Courtesy City of Sydney Archives
Chippendale Residents Interest Group
Email: chippendalecommunity@gmail.com

25 May, 2013

Central Park Blocks 6 & 7 Kensington Street
MP 11_0091 - Proponent's "Response to Submissions"

Figure 3-1 - Roof terrace areas - located on level 2 and 3 of number 10 (left) and 14 (right) Kensington Lane

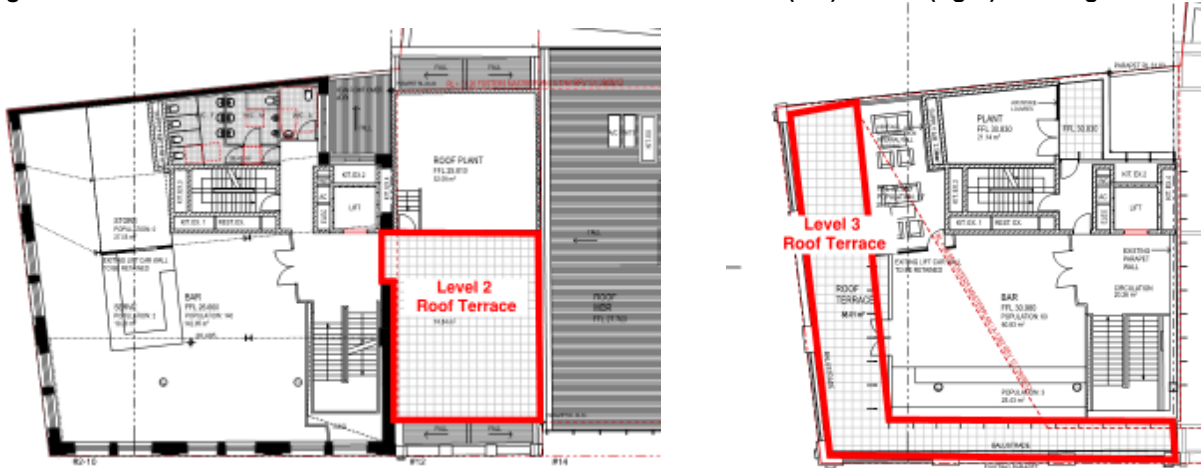
The addition of outdoor roof terrace decks is detrimental to the amenity of local homes and not supported as the noise will impact residents throughout the day and evening. We note many residents are shift workers - who already face the impact from poor residential amenity. Reducing their amenity further cannot be supported.
